Application number: 2025/90527	
What is the application for?:	Change of use of land to domestic garden, formation of access and hard surfacing
Address of the site or building:	Land adj, 67, Elm Tree Close, Norristhorpe, Liversedge, WF15 7BU
Postcode:	WF15 7PG

TYPICAL FENCING ELEVATION 1:50

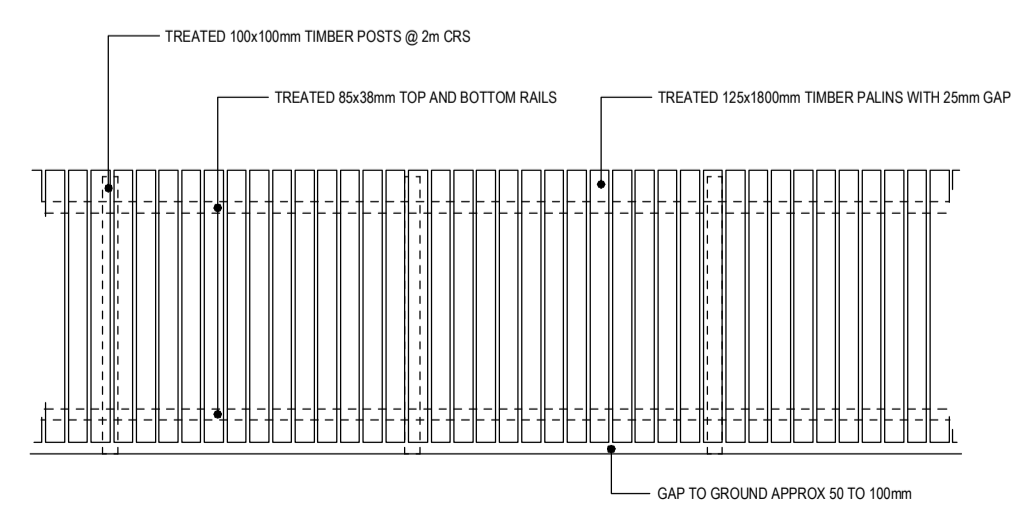
Type of comment: An objection	
Do you wish your comments to be published on the website anonymously?	Yes
<p>I think that the fence is too high, not in keeping with the surroundings. It has barbed wire around the top on the inside of the fence which is dangerous to wildlife and neighbouring cats. Trees have been planted which could over grow the height of the fence and in time block sunlight from neighbouring properties.</p> <p>I'm not opposed to the fence but believe it's too high.</p>
